**WEST SUSSEX COUNTY COUNCIL
PLANNING SERVICES CONSULTATION**

DATE: 12th January 2018

SUBJECT: Y/92/17/OUT - Outline application with all matters reserved save access, for up to 300 dwellings, link road, surface drainage, open space and landscaping. Departure from the Development Plan and Access route is within the Yapton (Main Road) Conservation Area.

Land east of, Drove Lane, Yapton, BN18 0EB

|                                             | Drawing Title:       | 2021 AM Base + Committed + Development<br>(07:45-08:45) 300 Units | Date:<br>-        |

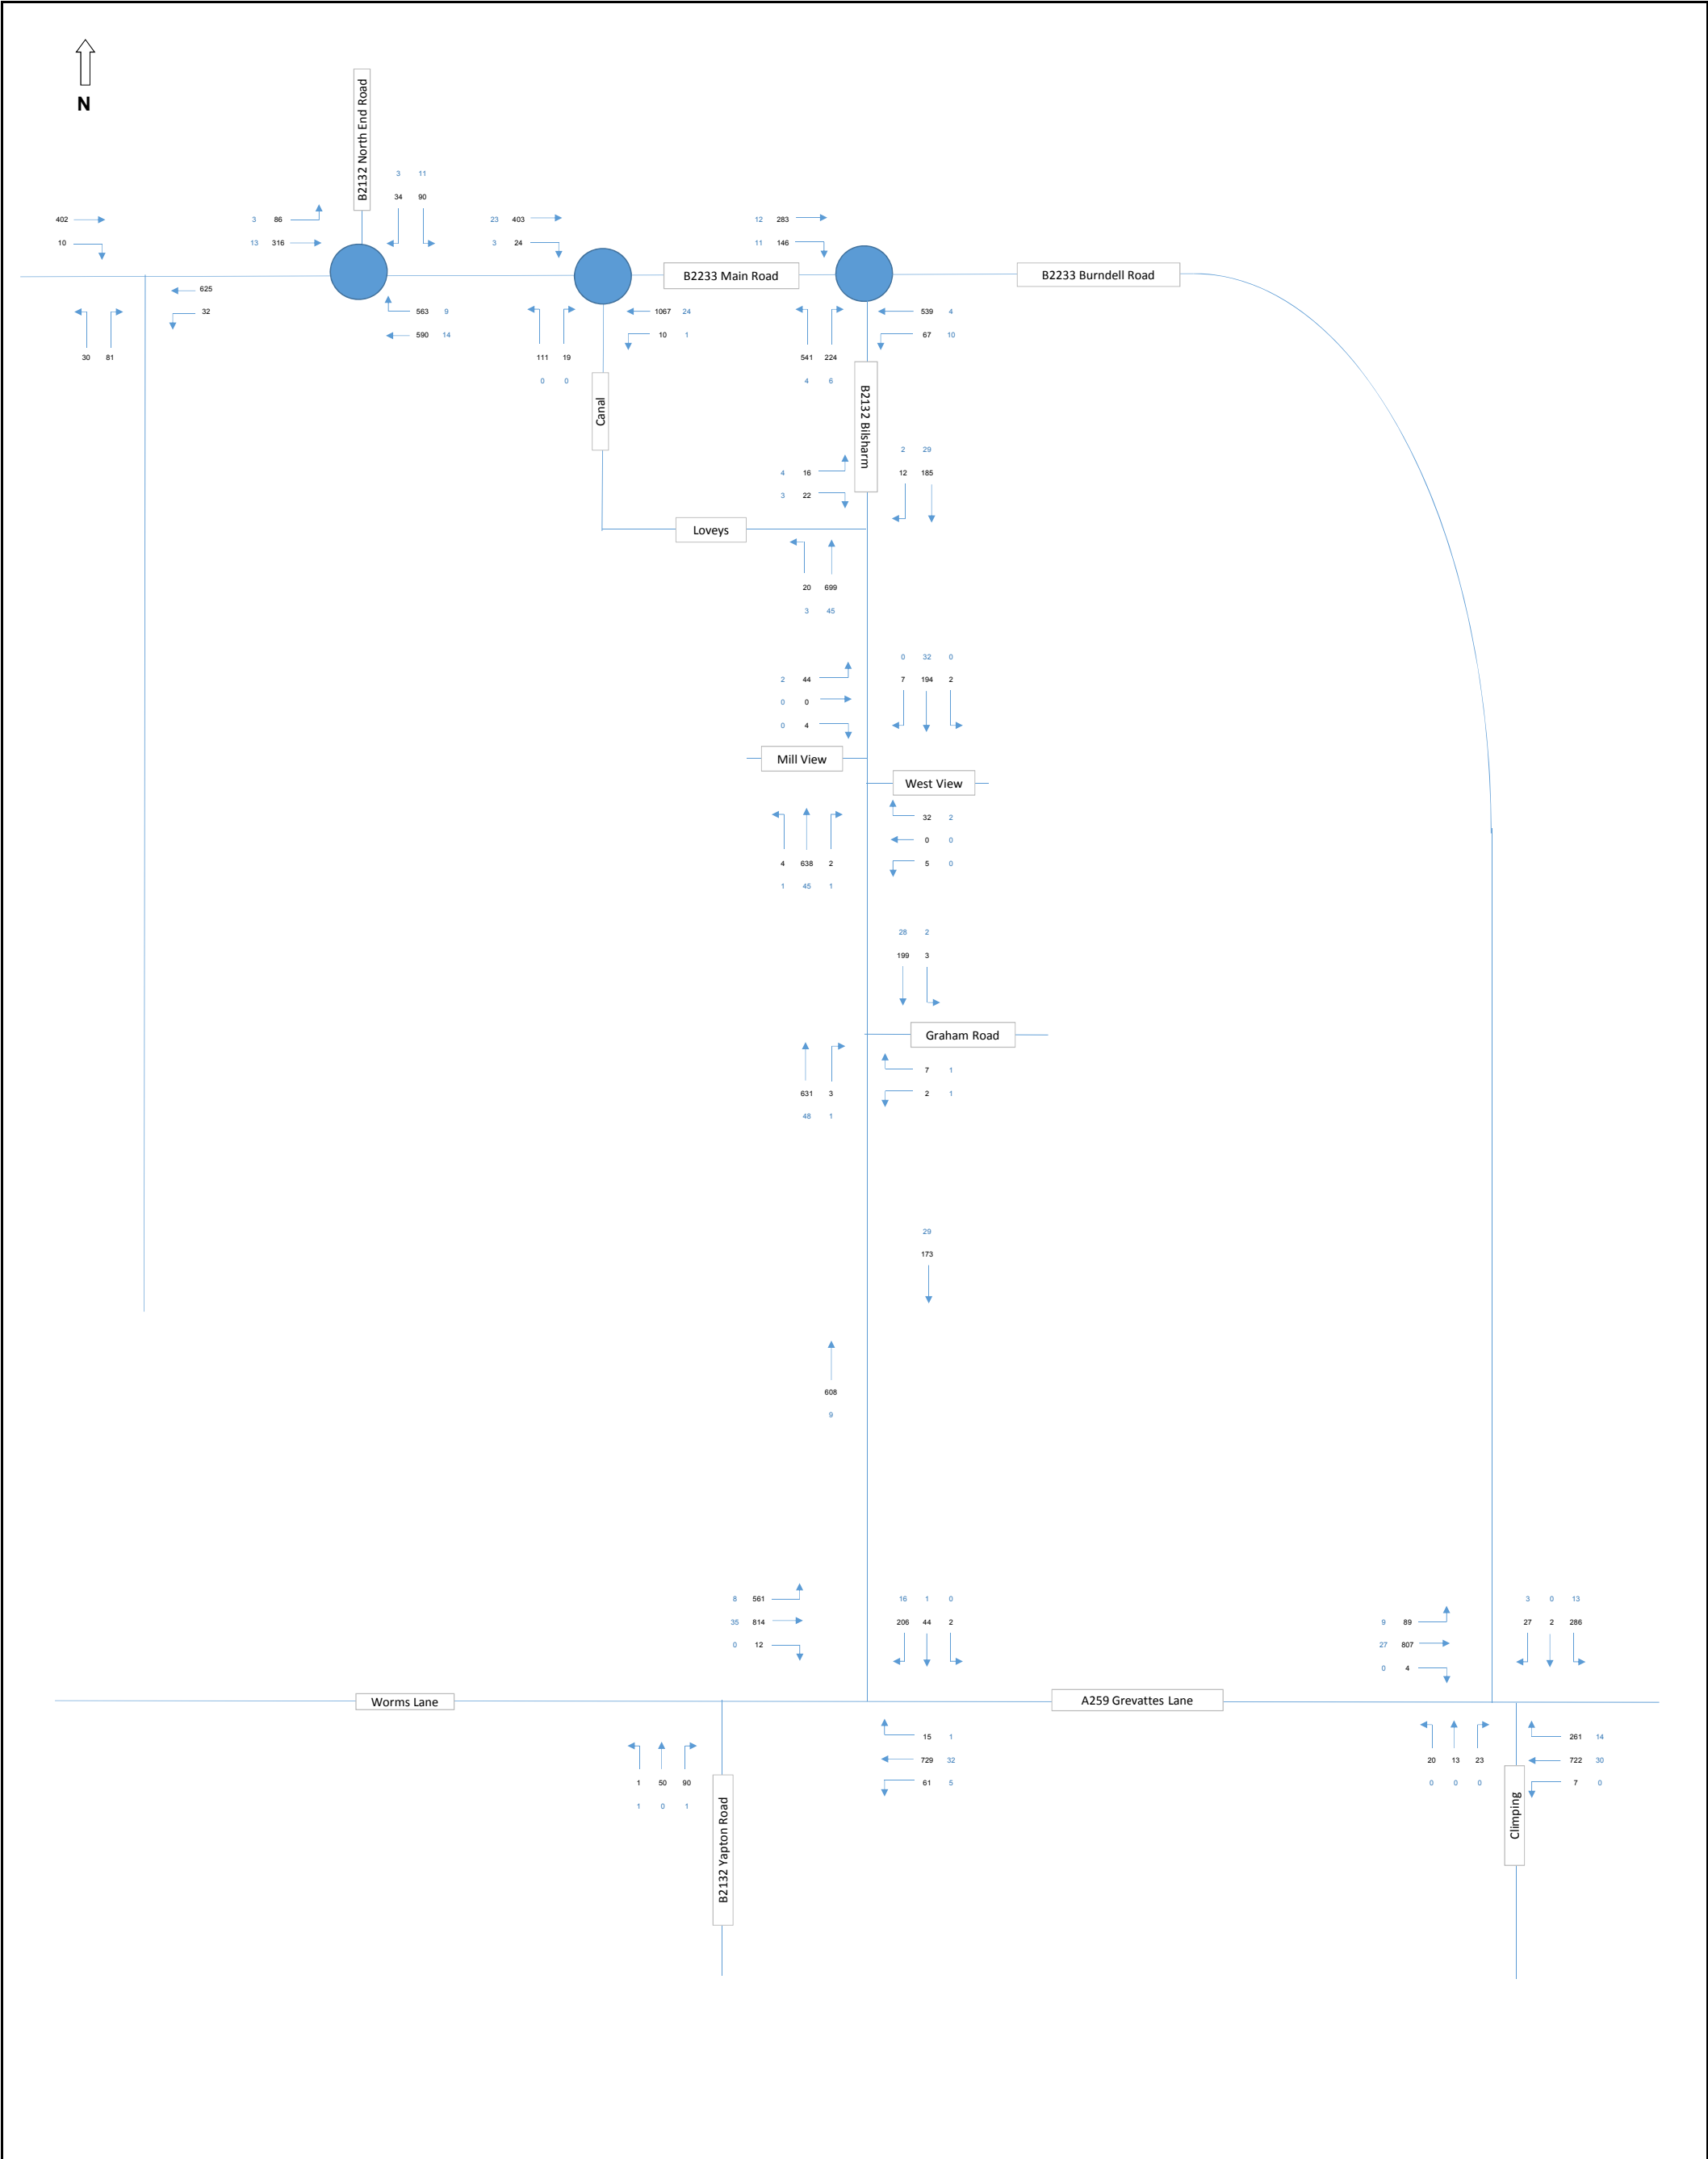
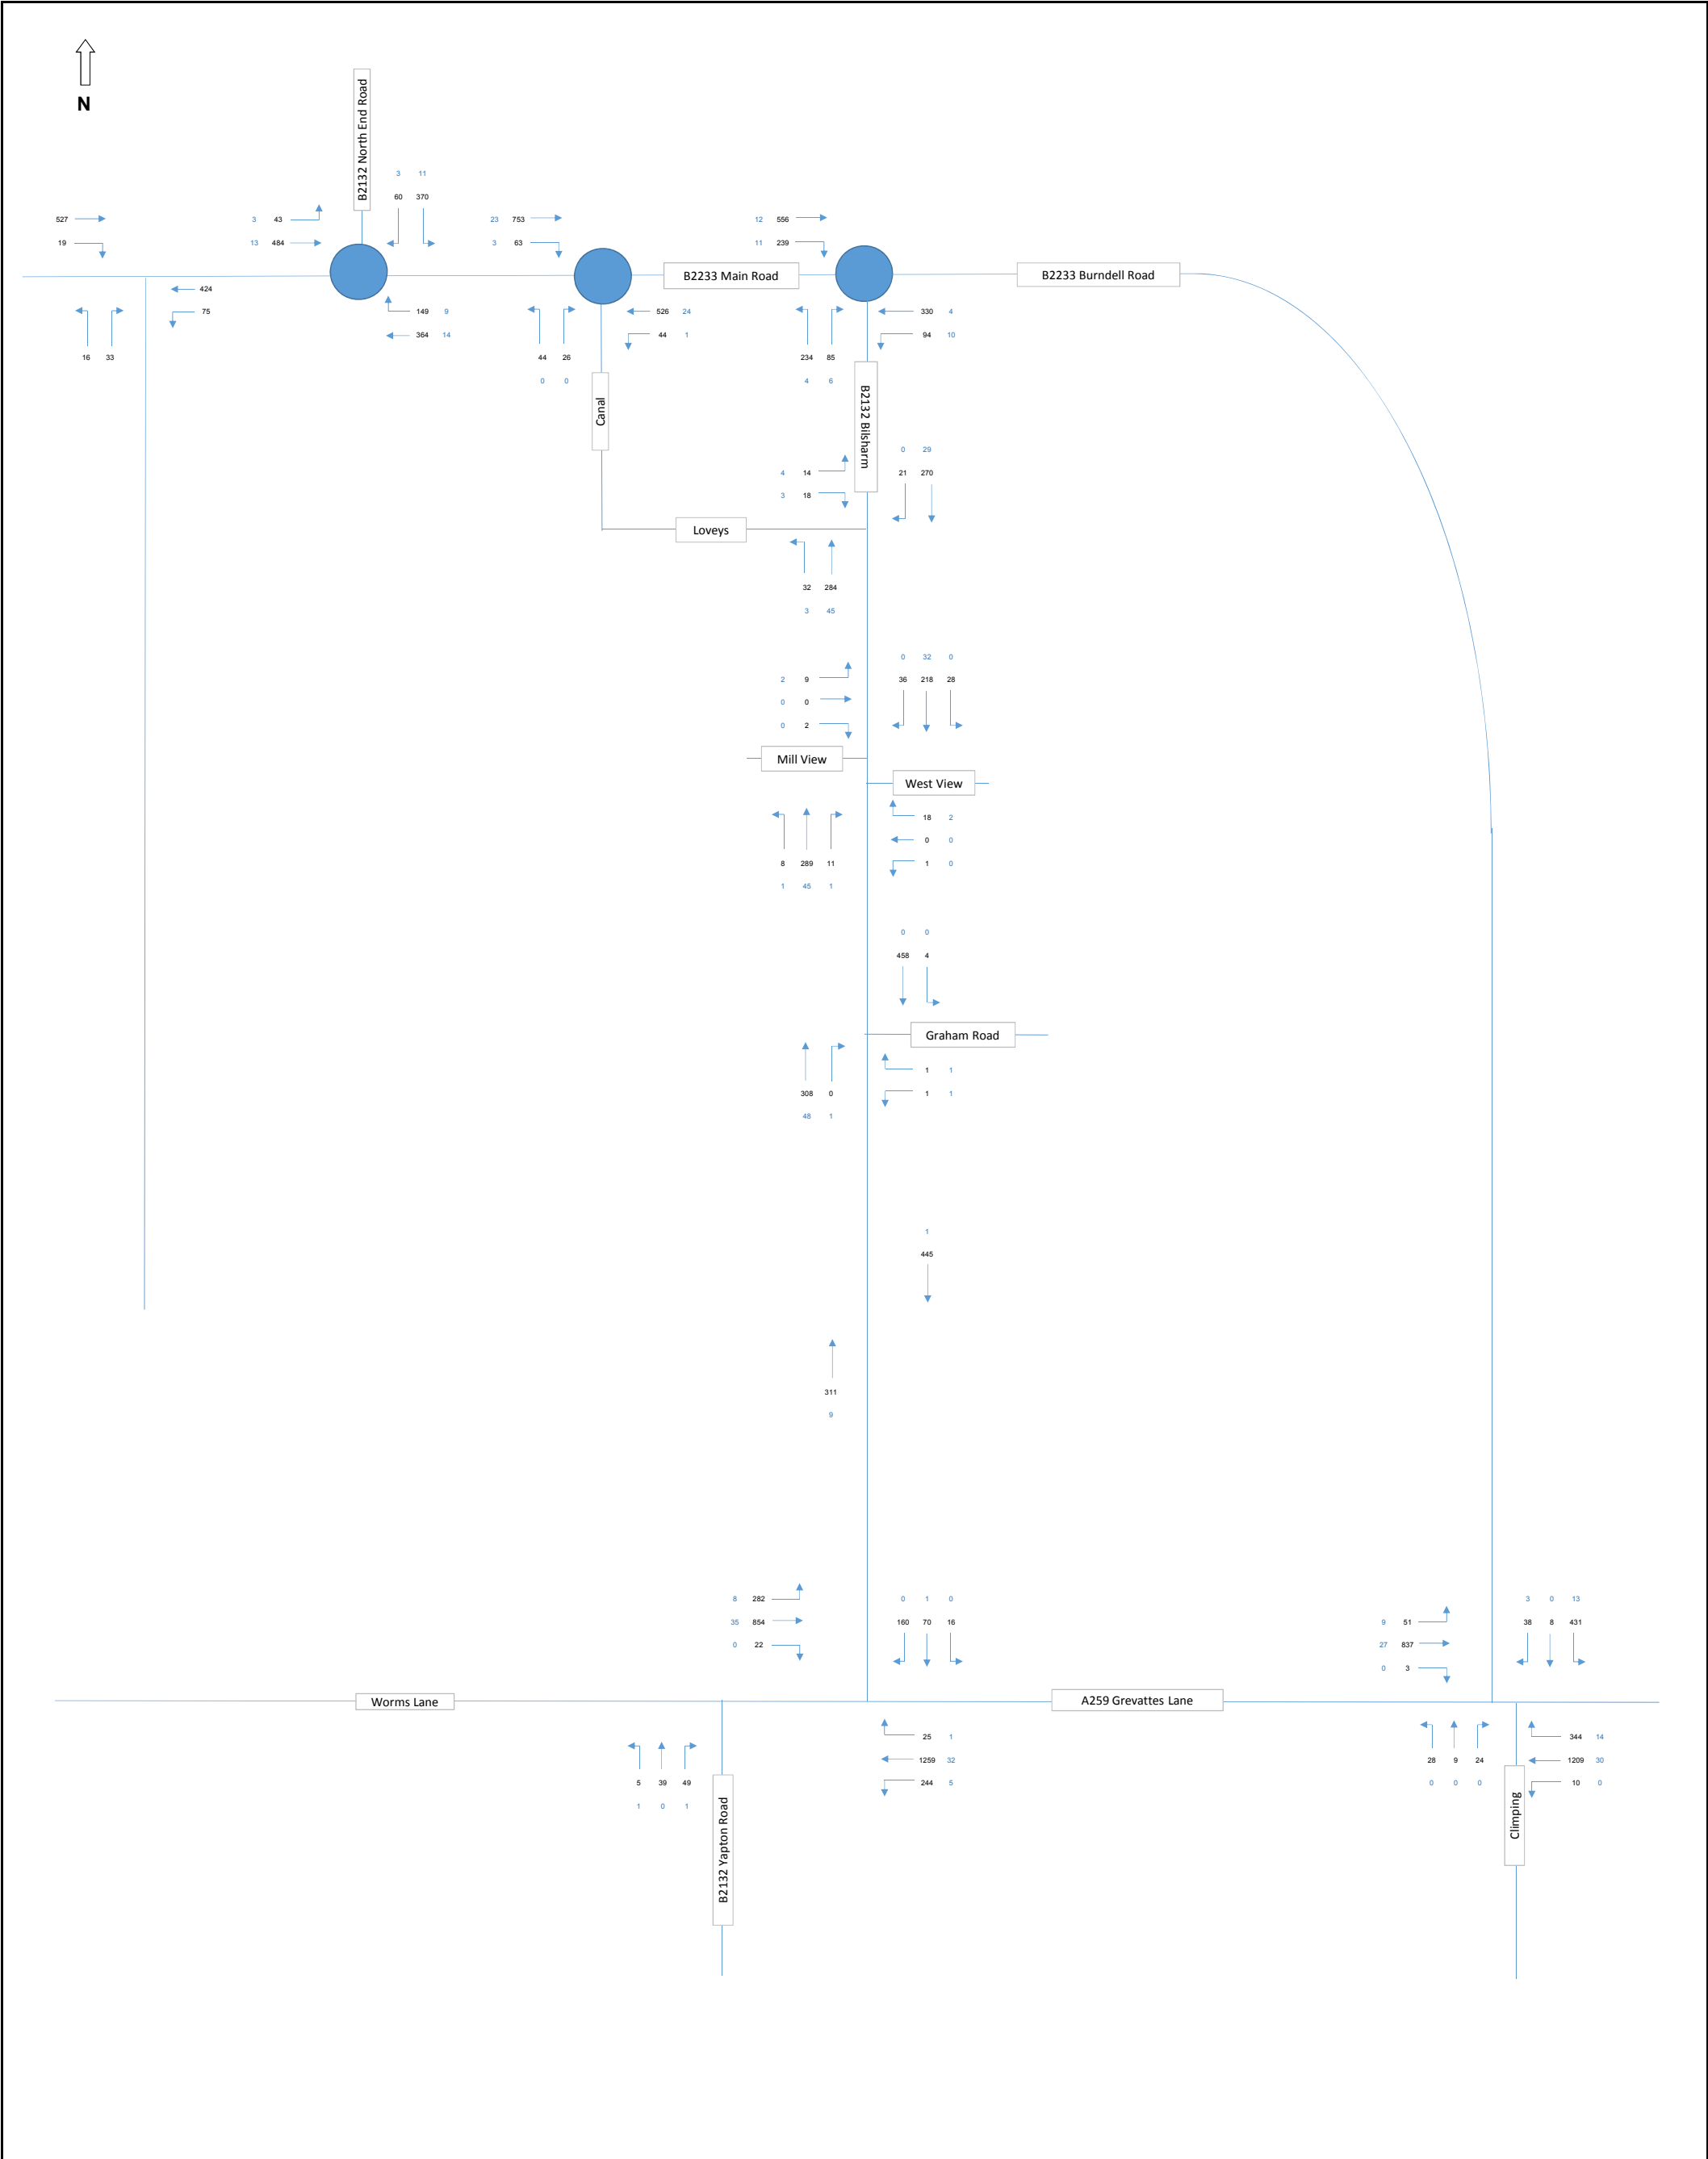
Also no figures highlighting the flows generated by the development have been provided within the application.

1. Review of links to local facilities
2. Work undertaken to review walking and cycling improvements to Barnham Station.
3. Confirmation of trip generation and TRICS parameters.
4. Details of the gravity model used to distribute trips.
5. A traffic flow diagram showing the impacts of the development (and in combination with the adjoining site)
6. Review of committed developments with the LPA.
7. Revised modelling following agreement of 3,4,5 & 6.
8. Liaison with Highways England over the impacts upon the A27.
9. Amendments to the Travel Plan.

FIGURE 54. Proposed access arrangements for the site

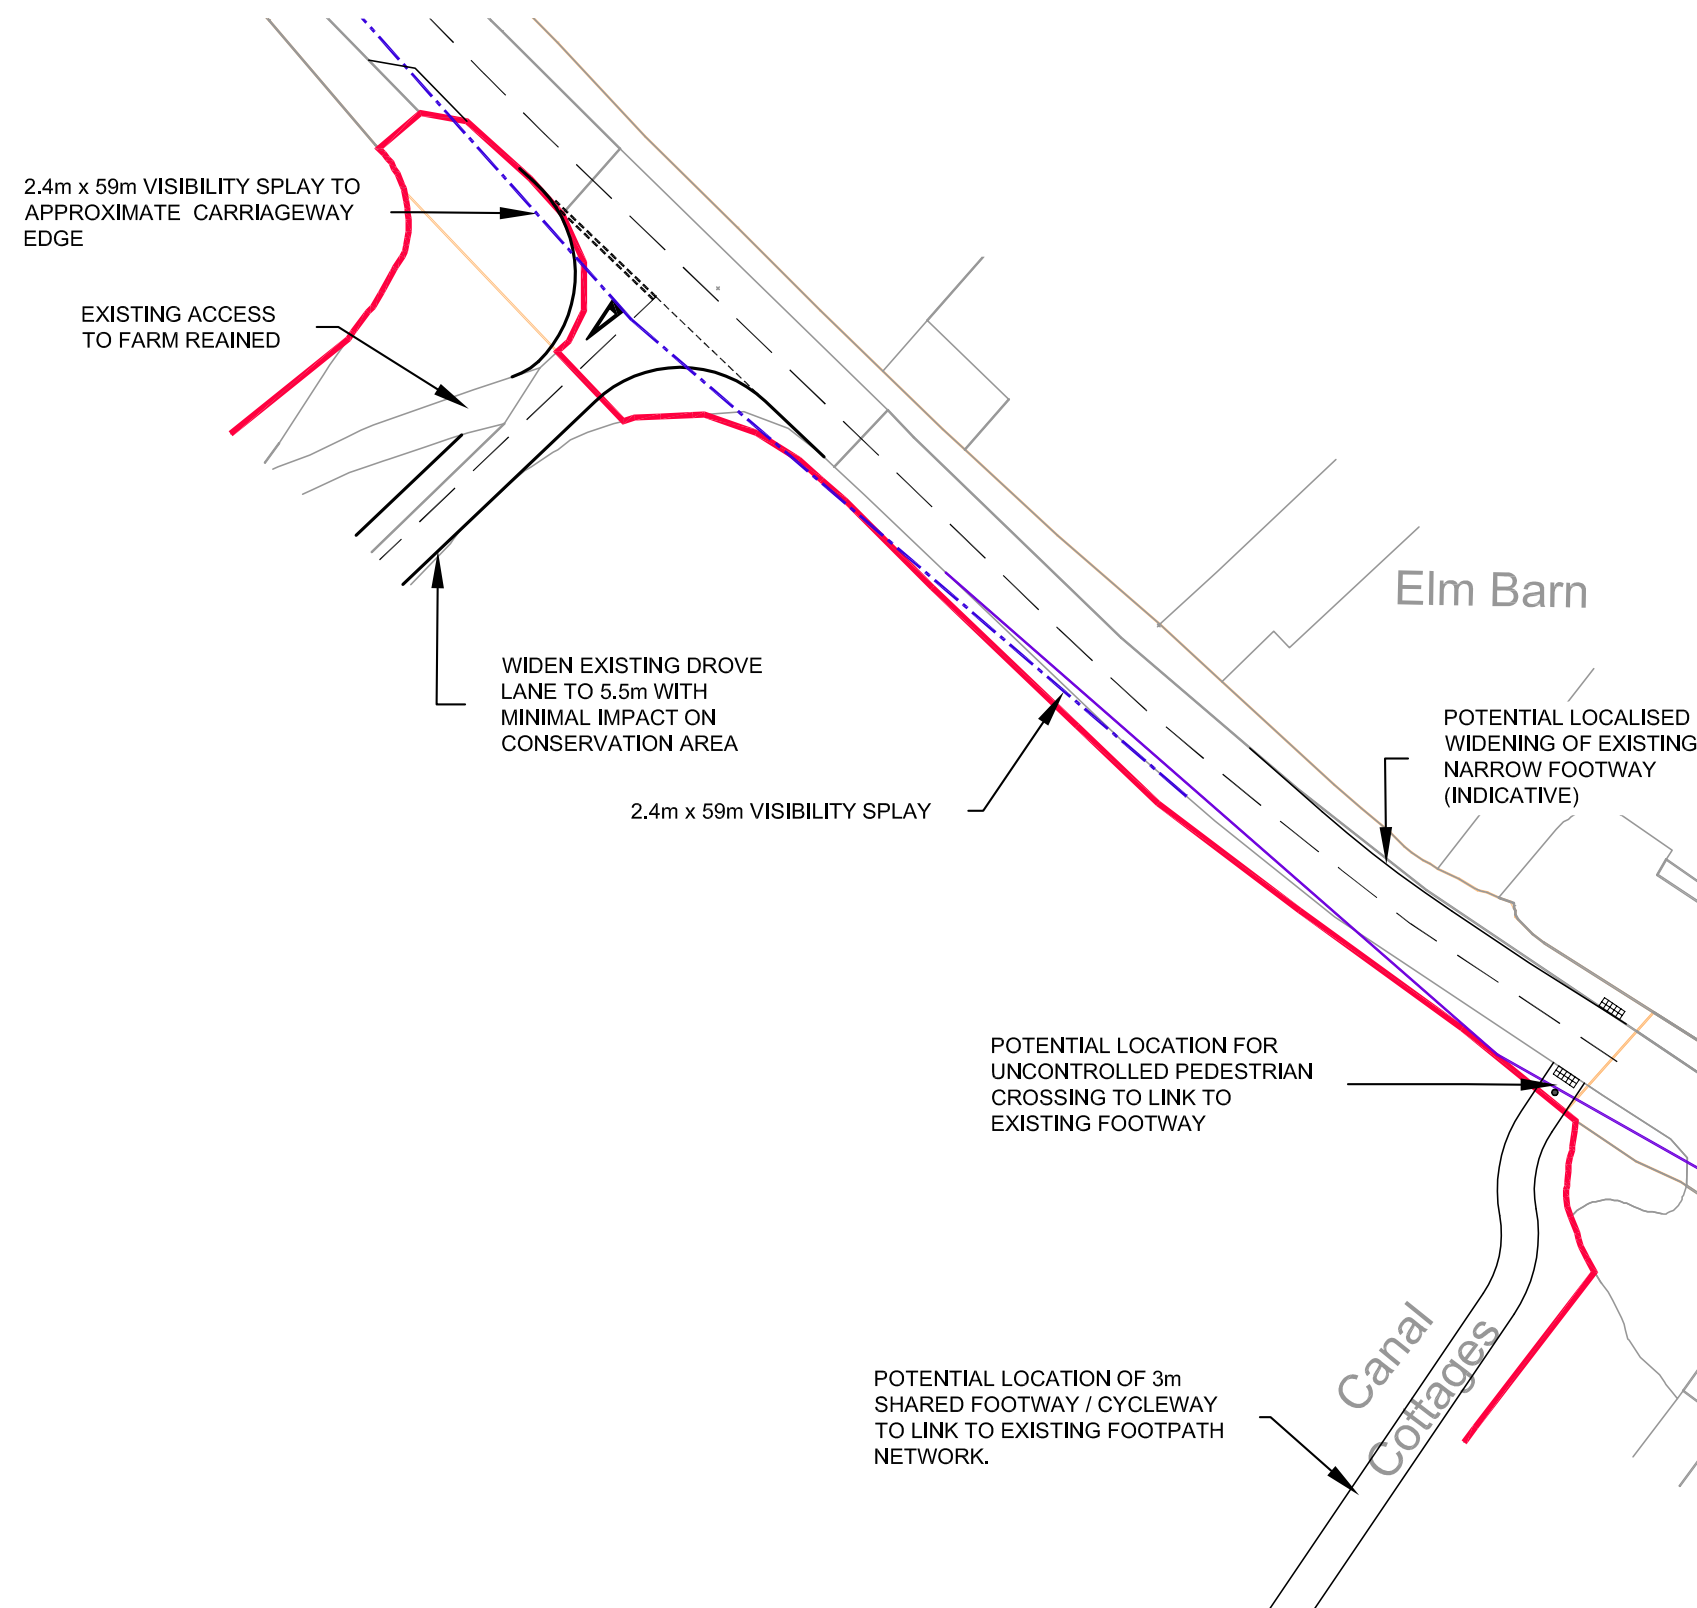
The site will be accessed via a the existing Drove Lane junction which will be widened to 5.5m to allow two way movement and visibility splays of 2.4m x 59m provided . A Road Safety Audit has been undertaken and designer's response provided.

No footway is proposed along the access, Pedestrian access will be provided adjacent to Canal Cottages with an uncontrolled crossing provided on the B2233 Main Road (also shown as an emergency access on drawing ref 1244L03). The two developments will be linked a single spine road designed to manual for streets standards.
